PARKVIEW PLACE - BUILDING A

**ACCESSIBILITY
REVIEW**

Morris-Goding Accessibility Consulting

11th November 2009

DRAWING TITLE
Basement 01 Plan

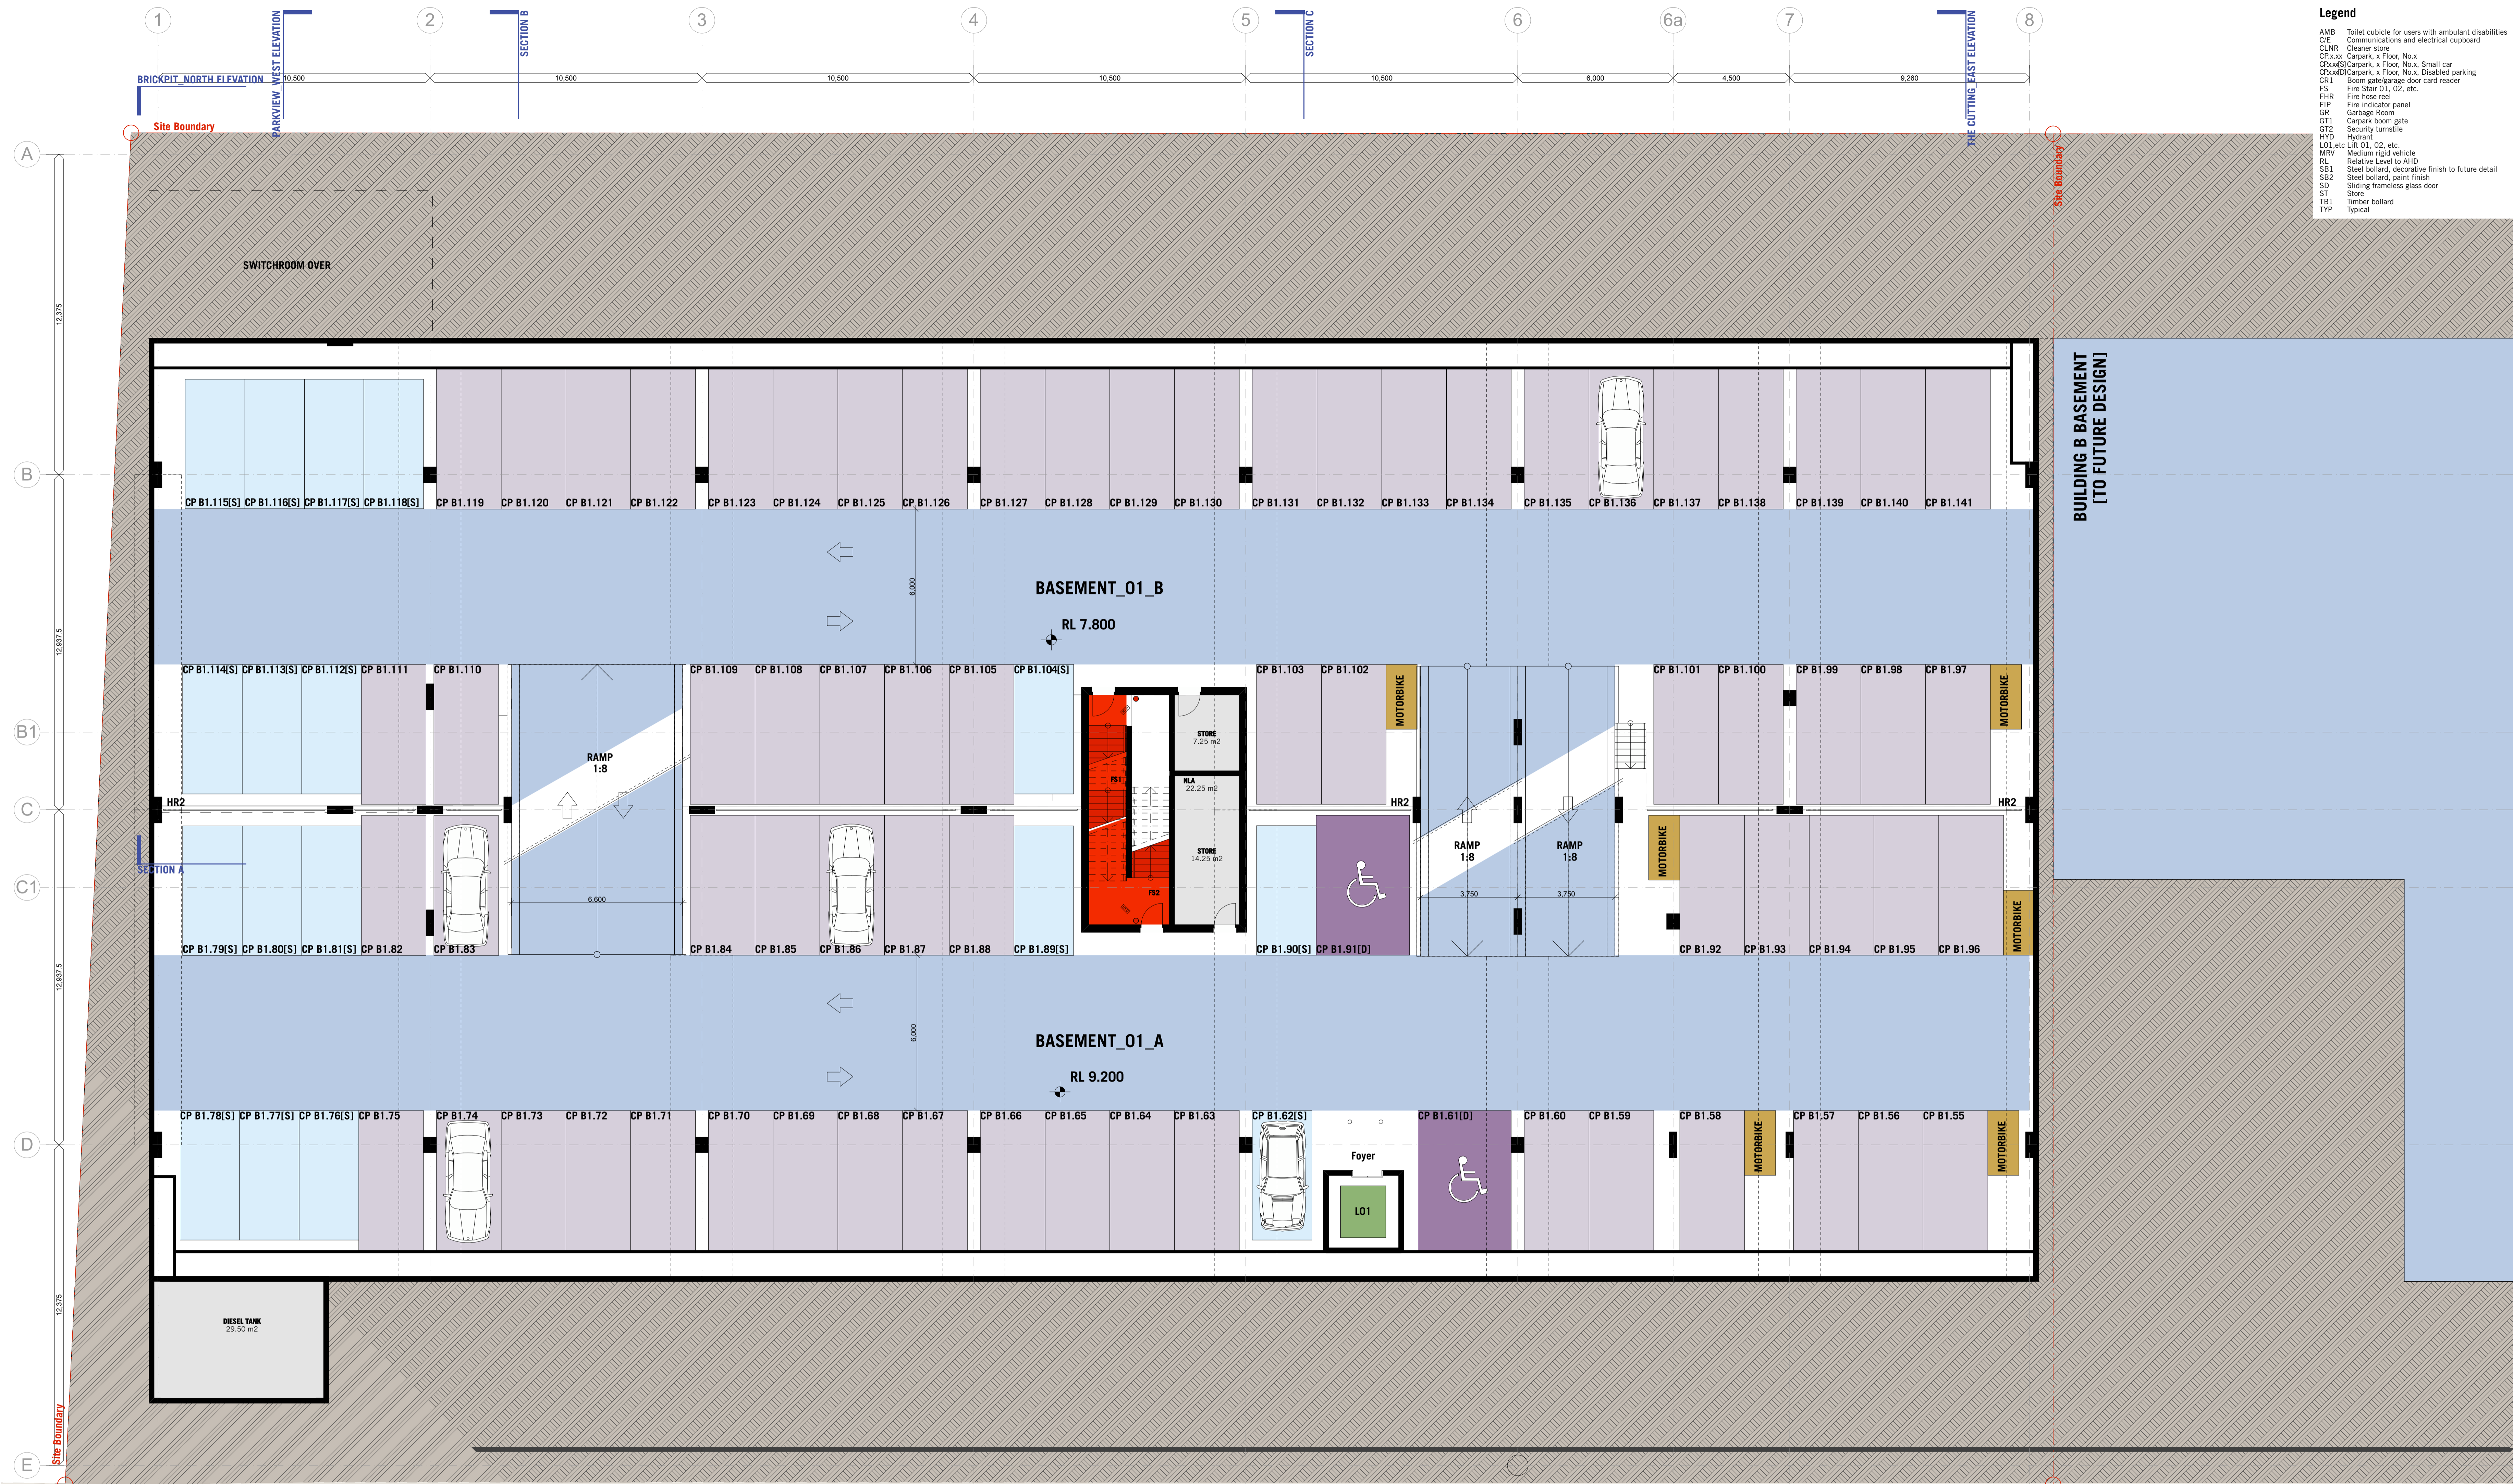
However area in front of the basement 01 passenger lift is limited. There is a distance of 1400mm between the passenger lifts and the bollards.

- (i) Ensure passenger lift cars have minimum 1700mm x 1400mm internal dimensions.
- (ii) Ensure the distance between the passenger lifts and the bollards (basement 01), is increased to 1800mm, compliant with the SOPA Guidelines Second Edition – December 2008, clause 2.4.
- (iii) Ensure all lift cars have internal components (control panel, handrails, visual & audio devices) that comply with AS1735.12.
